Kirklees Flood Management & Drainage (Lead Local Flood Authority) – Statutory Consultation

Consultation on Application Number: 2018/92686

Address: land adj, 127, Westgate, Heckmondwike, WF16 0EW

Proposal: Outline application for erection of retail (A1) and drive thru restaurant (A3) development and associated car parking, landscaping and infrastructure

Title
Proposed Site Layout

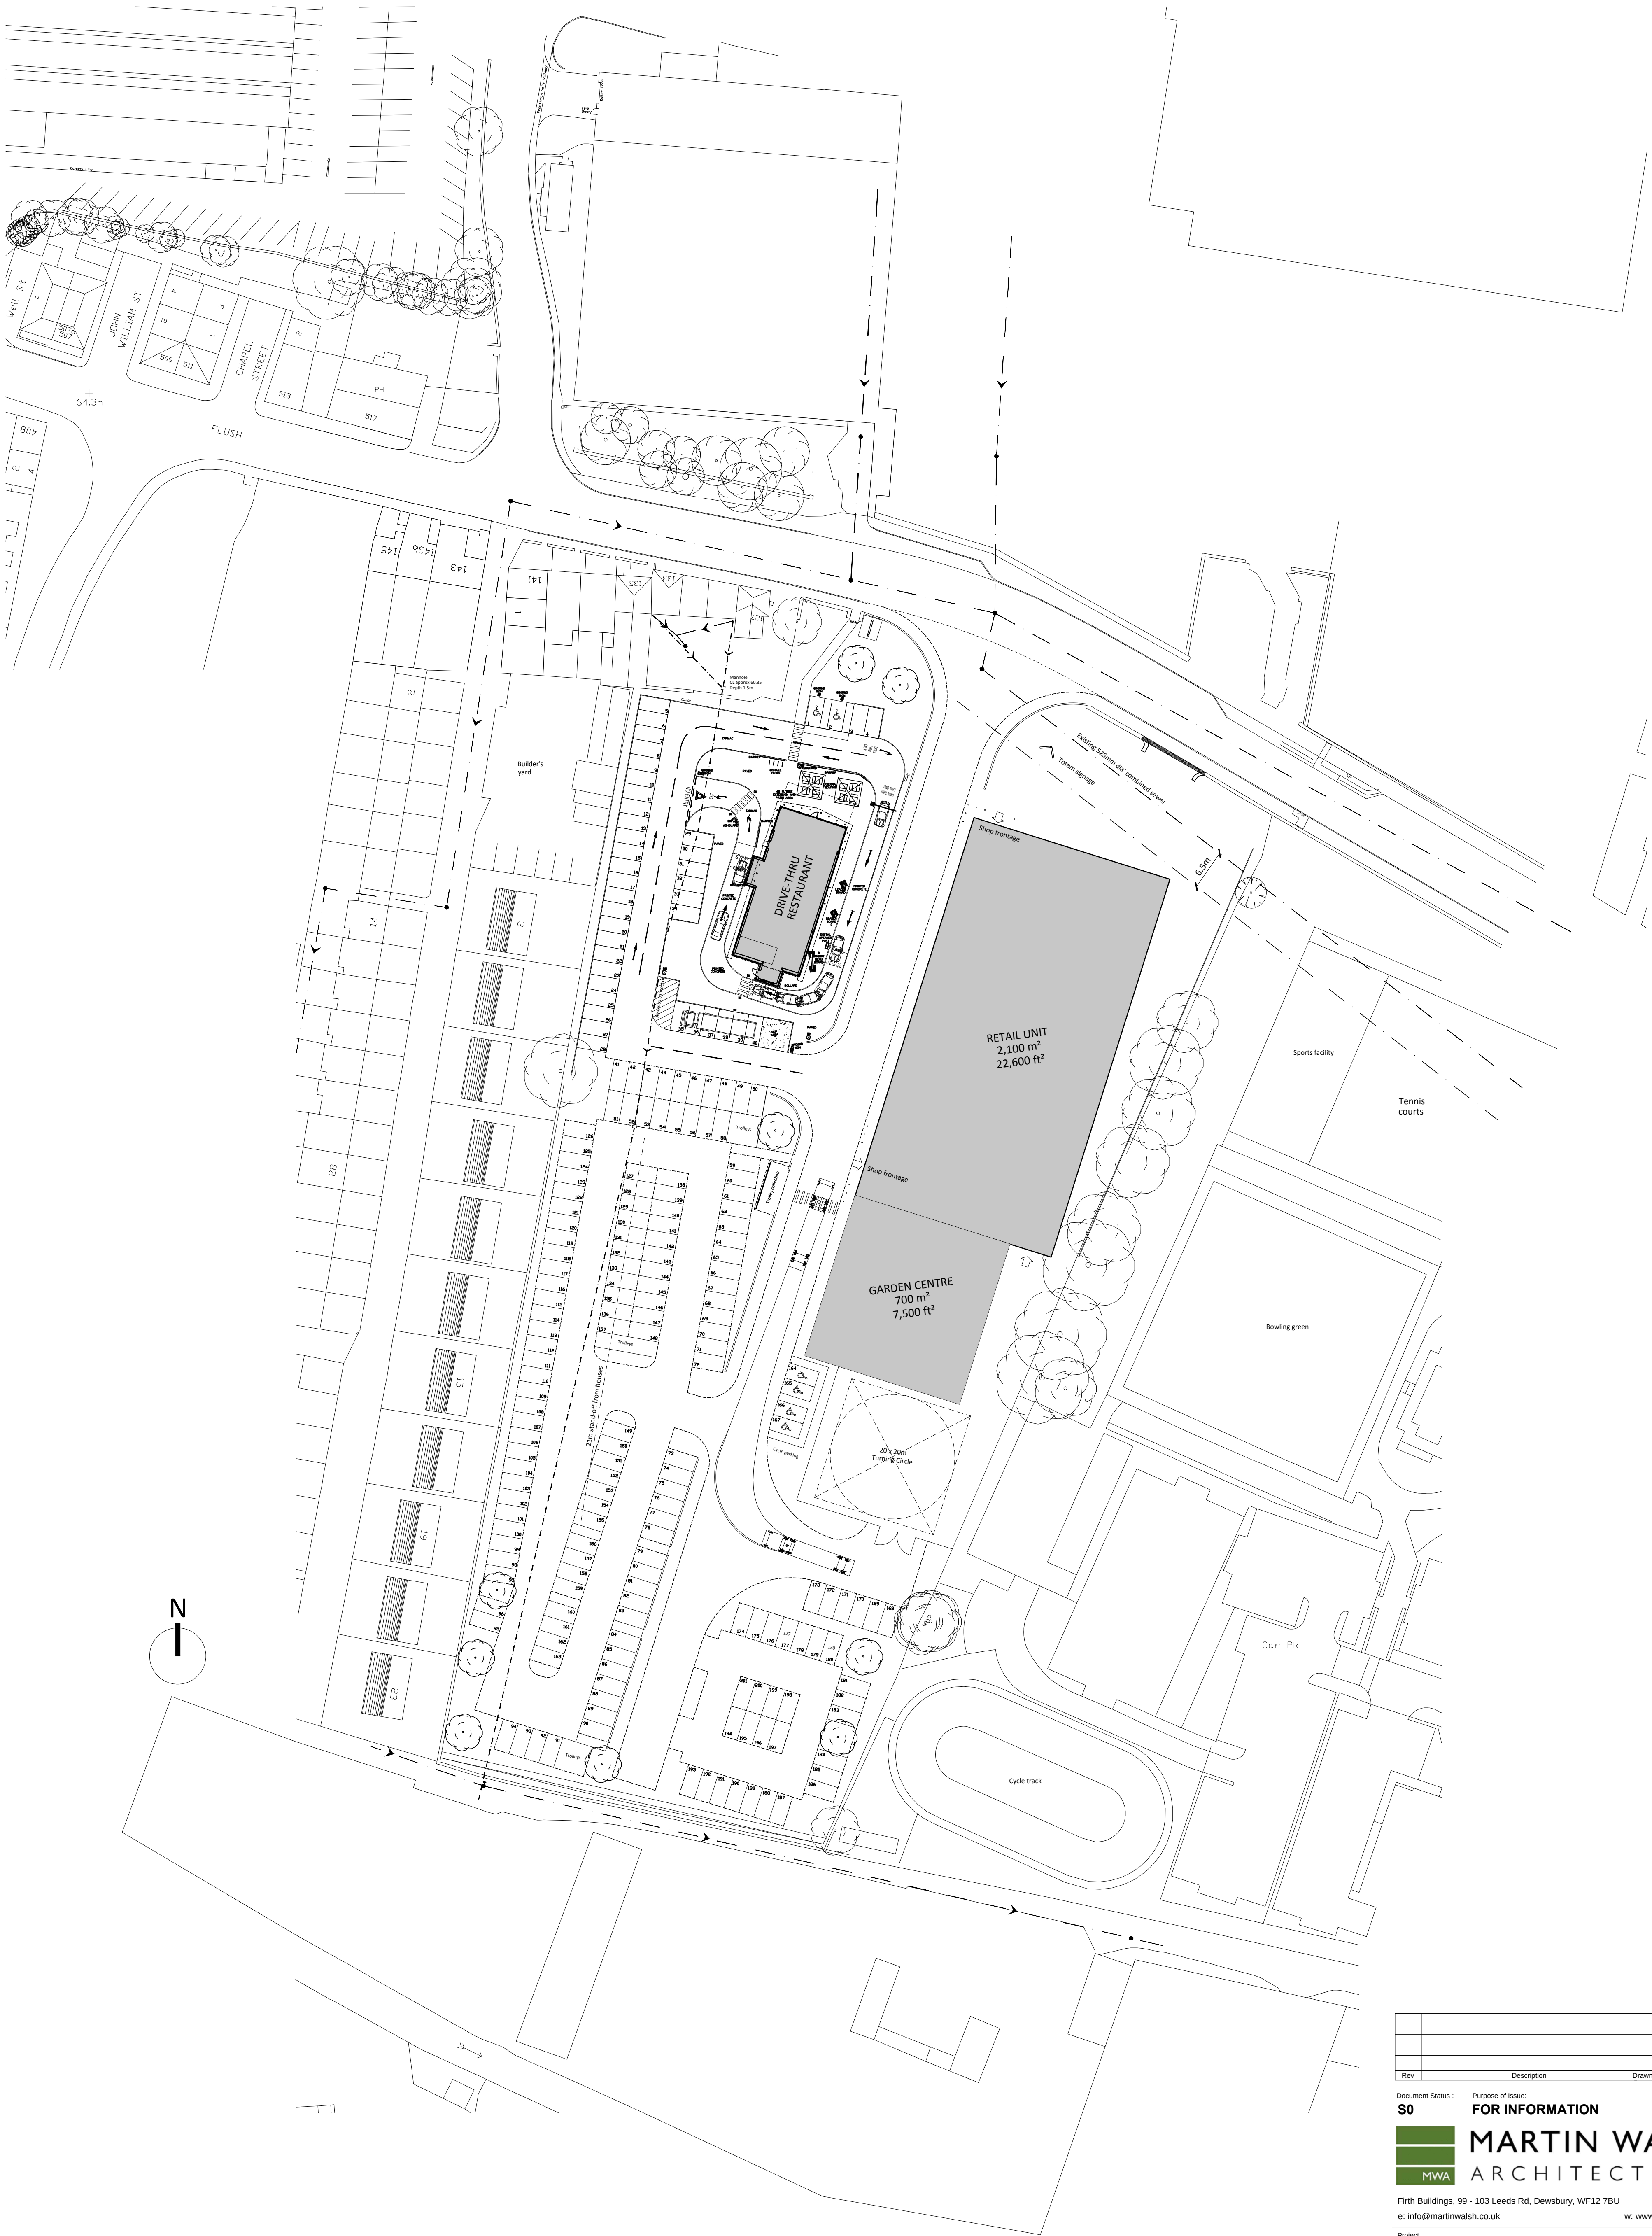
- A higher level flood risk assessment is now required to take initial assessment by Trevor Haigh forward and fully justify the layout design as submitted or provide a layout that avoids risk and where this is not reasonably practicable, adequately mitigates it again with justification.

There is an ordinary watercourse flowing under Westgate and the site before discharging to the river Spen. An access manhole is available in Westgate according to Kirklees records. The size, depth, condition and exact location of this watercourse must be surveyed prior to considering layout approval.

The LLFA will object to any proposals to build over this watercourse.

There is a 525mm public combined sewer crossing the site west to east inside the northern boundary. A significant stand-off should be expected and we advise dialogue with Yorkshire Water over recommended distances and whether diversions of such a system is feasible or desirable within the proposed layout which may need alter as a result.

In addition an addition combined sewer runs north to south for the full length of the site. Similar advice should be sought from Yorkshire Water prior to making a decision on layout.

We support a sequential approach where no buildings are placed in flood zone 3. We politely remind the applicant that flood zone 2 is not a 1 in 1000 year storm event but represents events between 1 in 100 and 1 in 1000, i.e. between a 0.1 and 1% annual probability of flooding. Flood zone 2 should also be avoided if practicable in a sequential approach. The proposed garden centre is located in Flood Zone 2.

Surface water flood maps show a clear route of flooding from all systems and overland flows above the site, crossing Westgate and flowing through the site. It also shows ponding based on current LIDAR data for the existing site of upto 900mm. A full survey of levels within Westgate and the proposals should clearly identify the area of entry and from this building must not only be protected but a clear flood route

identified and maintain through the road and parking areas. Artificial means should as walls which could change at future data are not recommended. A full assessment and justification of building position in relation to this aspect is required. Some ponding is acceptable but clearly 900mm would be vulnerable to parked cars. A before and after assessment to show how the site is designed around a flood route and a maximum of 300mm depth ponding is required.
